Recommendation Report for Planning Permission**REF NO:** FP/179/11/**LOCATION:** 30 Limmer Lane
Bognor Regis**PROPOSAL:** Demolition of existing dwelling & outbuildings & erection of 6 no. apartments with associated parking & landscaping (re-submission following FP/182/10/)**SITE AND SURROUNDINGS**

#	LO	30/01/2012	1st Issue
Rev	By	Date	Rev
Client John Owen			
Job 30 Limmer Lane Felpham, Bognor Regis, West Sussex.			
Drawing Proposed Apartments Highway works and Visibility			
Date	January 2012	Scale	1:100@A1 1:200@A3
Drawn By L.O.		Dwg. No. 030510/SL-40

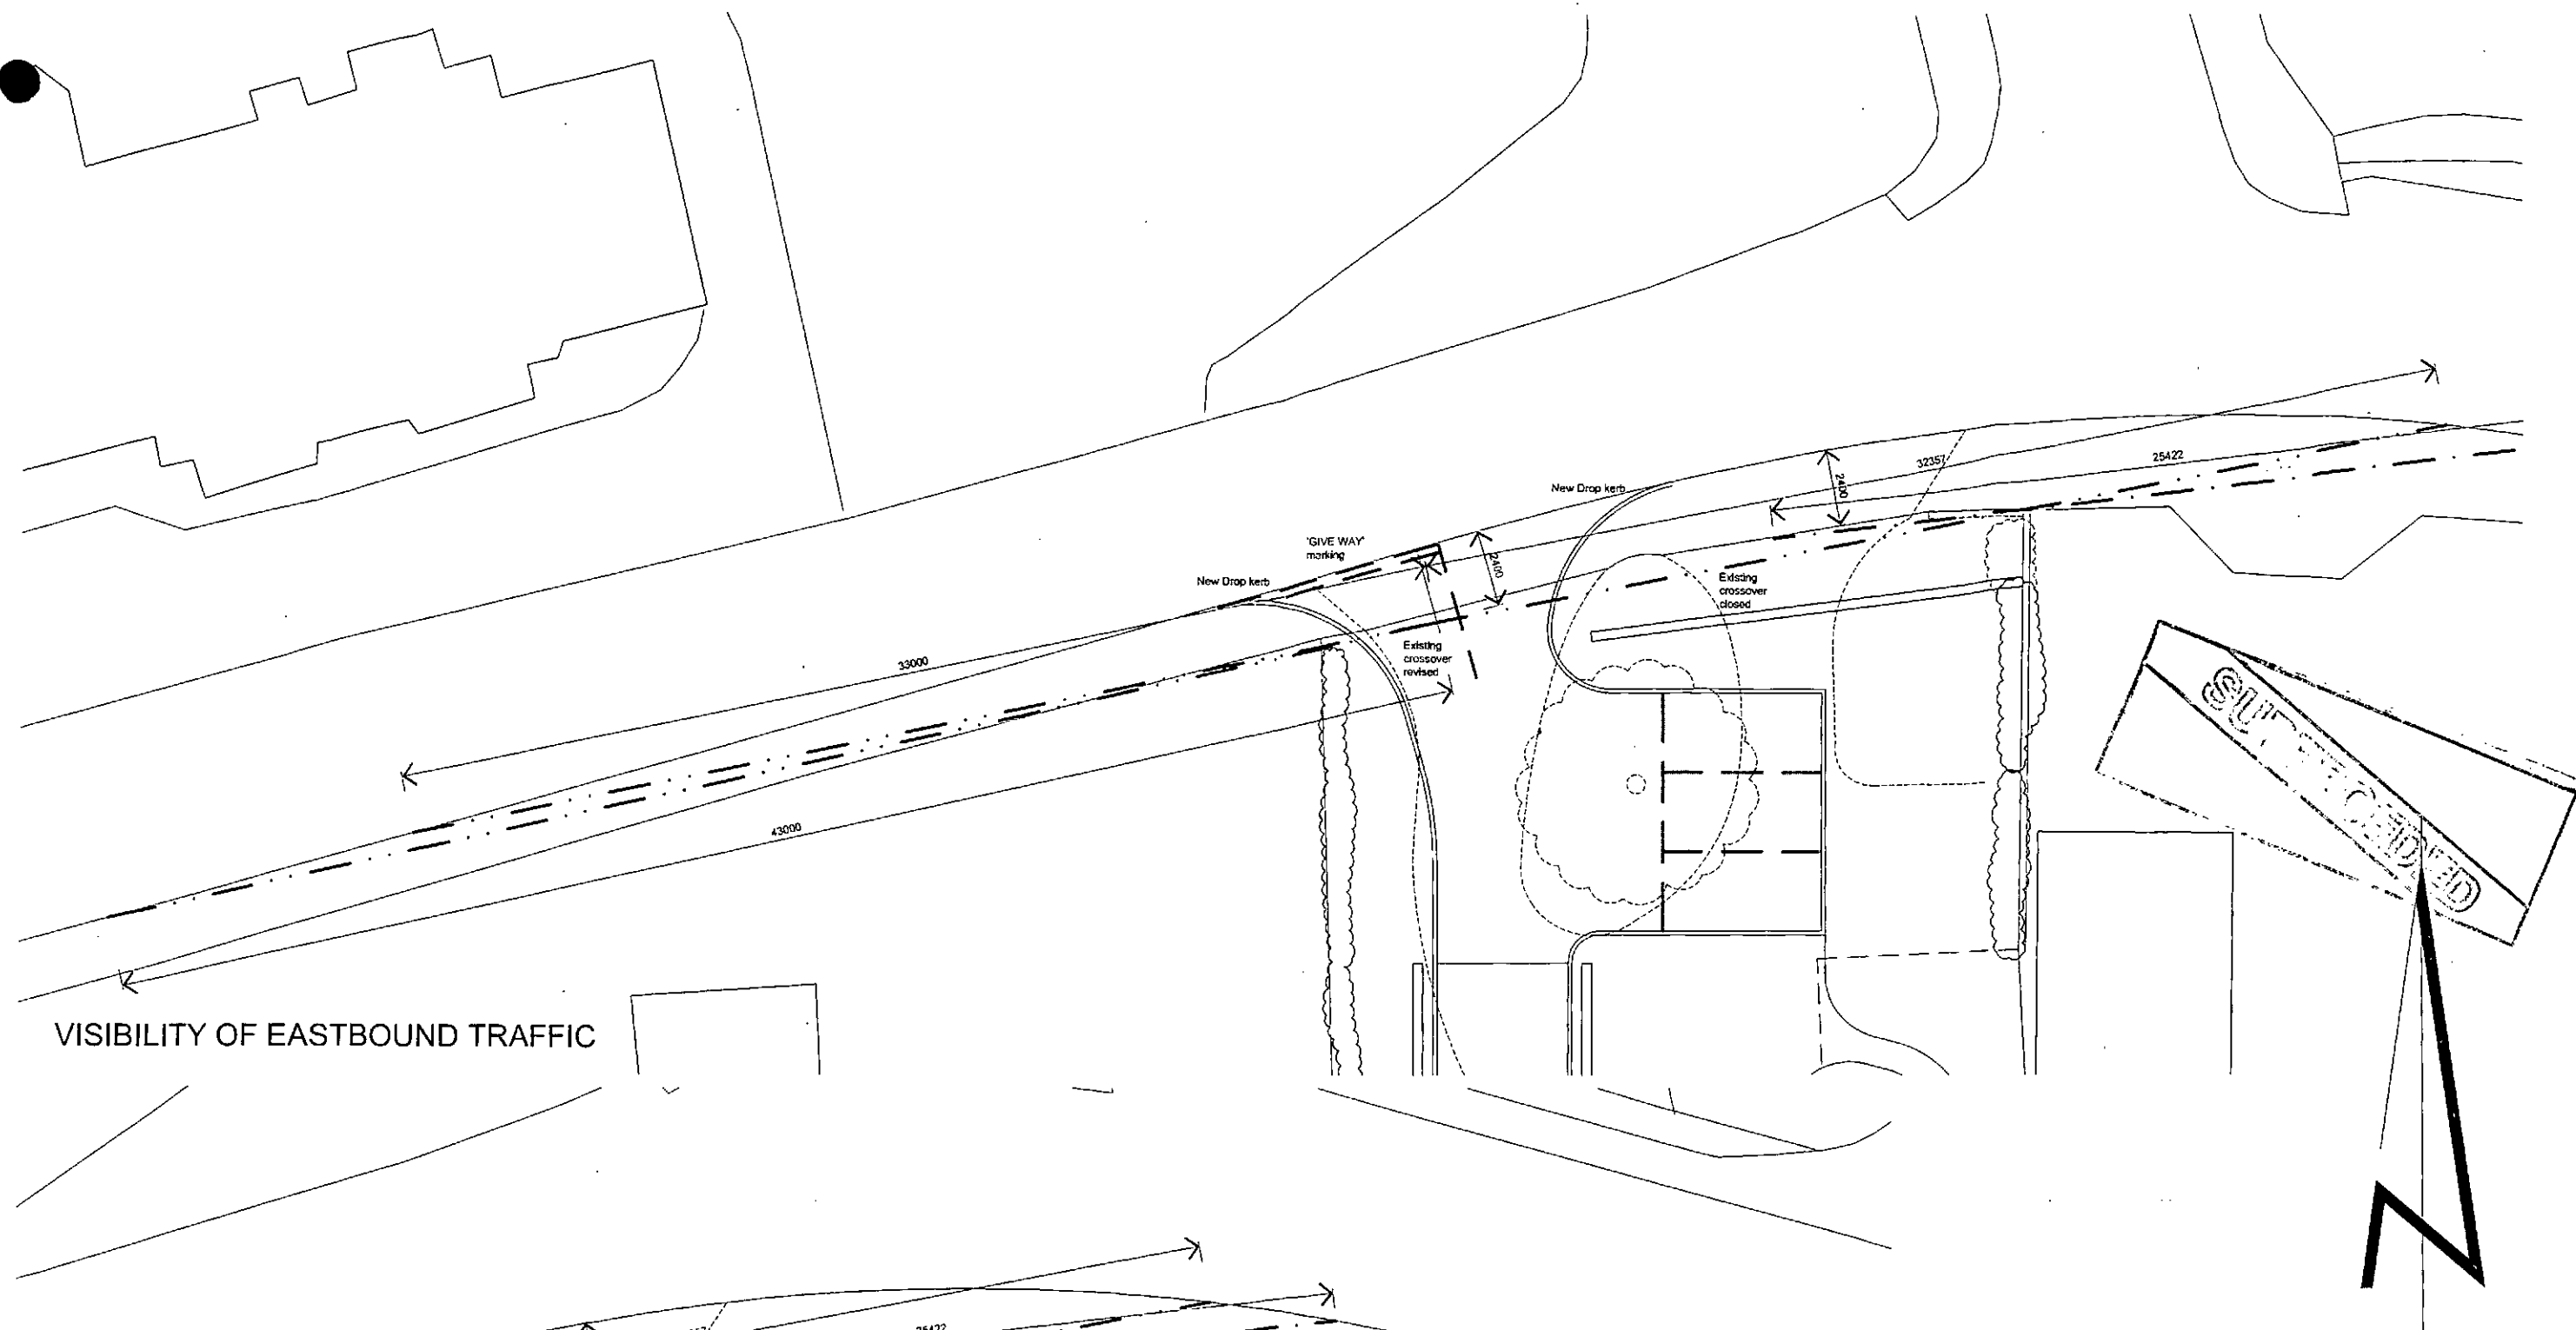
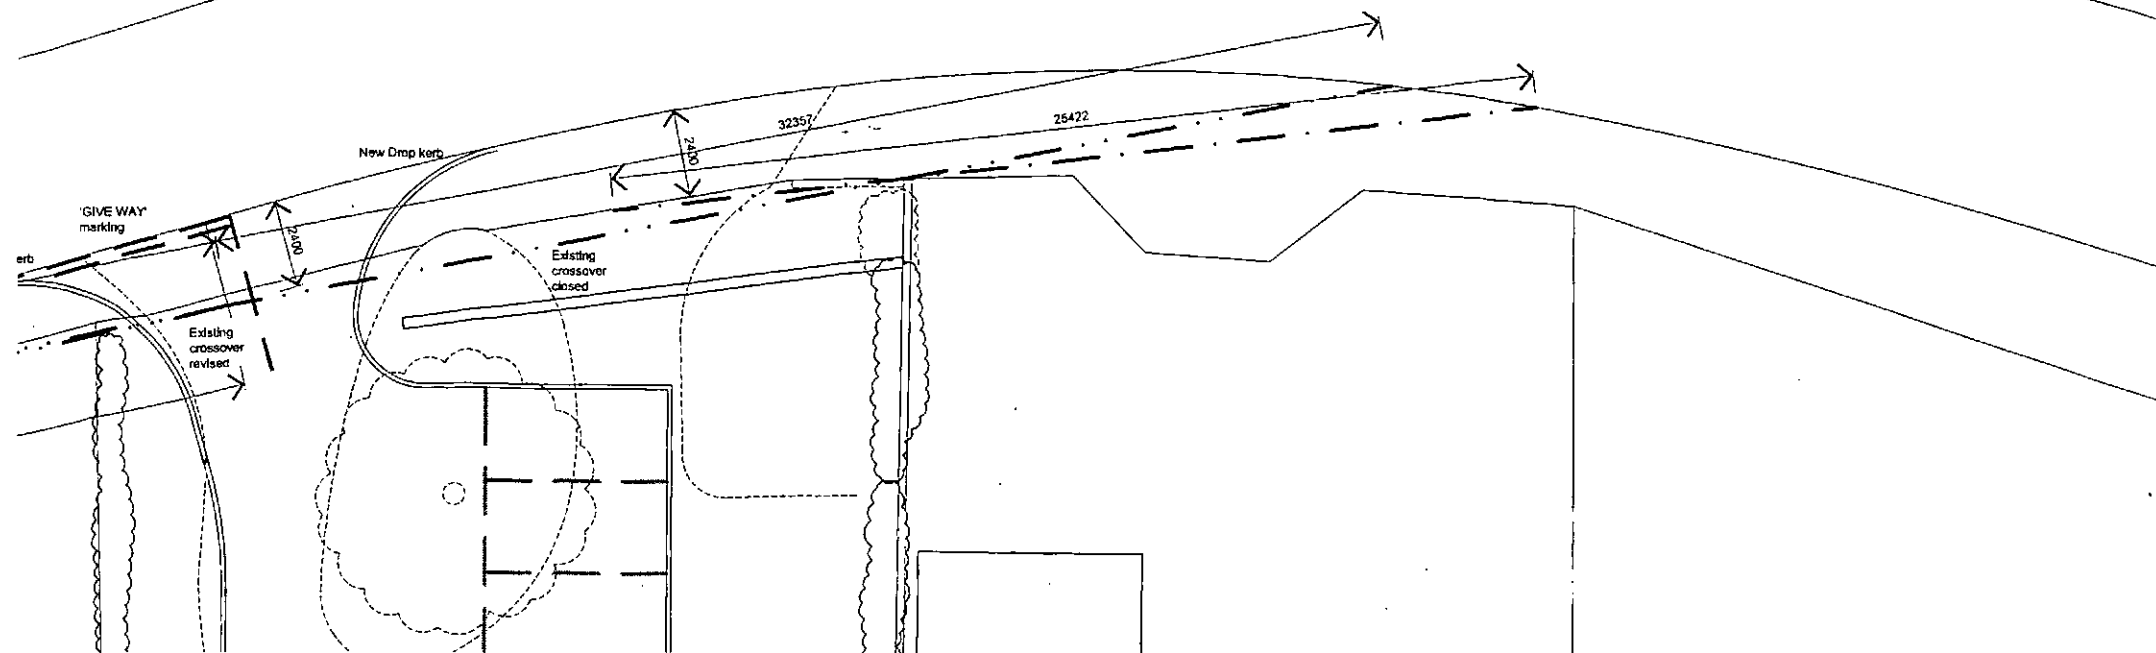
Recommend refusal. From the plans submitted it appears that appropriate visibility cannot be achieved without affecting third party land to the east of the proposed access position.

Notwithstanding the fact that this proposal does involve closure of the existing access, where visibility to the east is even less than that proposed, and the formation of a new access the

development of 6 apartments will result in an increase in vehicular movements over what currently exists. As a result the new access is unacceptable and does not meet appropriate standards.

The highway advice confirms that the proposal to close one existing crossover and modify the other does not provide the required visibility and therefore does not constitute a safe access arrangement.

- 1 The access is unsatisfactory to serve the proposed development of 6 apartments by reason of inadequate visibility in conflict with policy GEN7 of the Arun District Local Plan.

SITE LAYOUT PLAN (1:100)

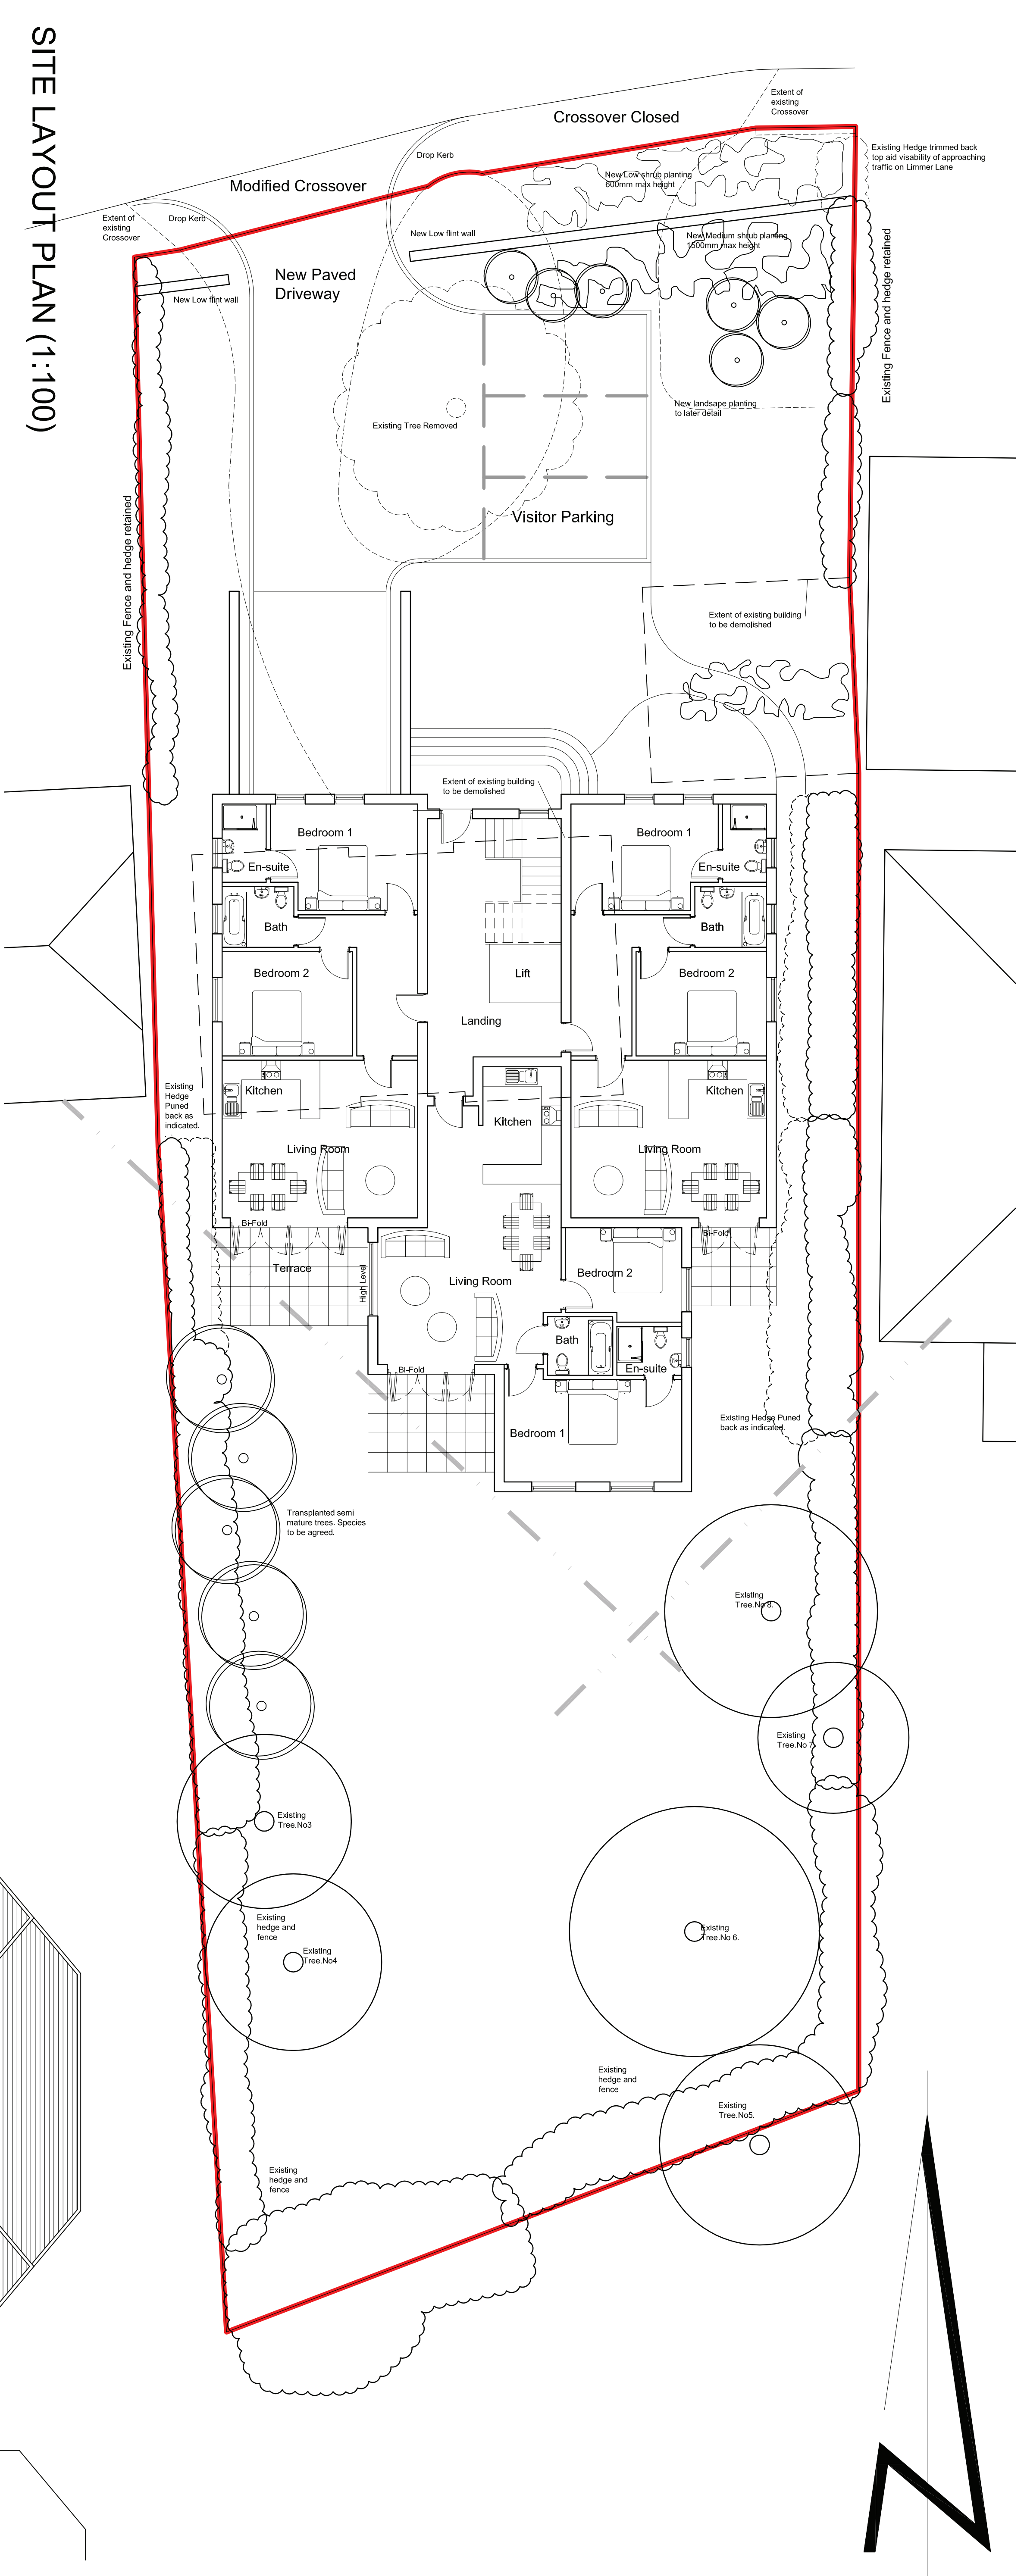
Details of planting are required. A tree protection scheme must be in place before construction begins. Trees T3-T8 to rear should be detailed, listing species, particularly any subject to a TPO.

Elevations have been amended to incorporate symmetrical fenestration. Comments made by Landscape Officer are included in the landscaping conditions. An acceptable revised FRA has been submitted. There was a typographical error in the earlier stated existing floor levels.
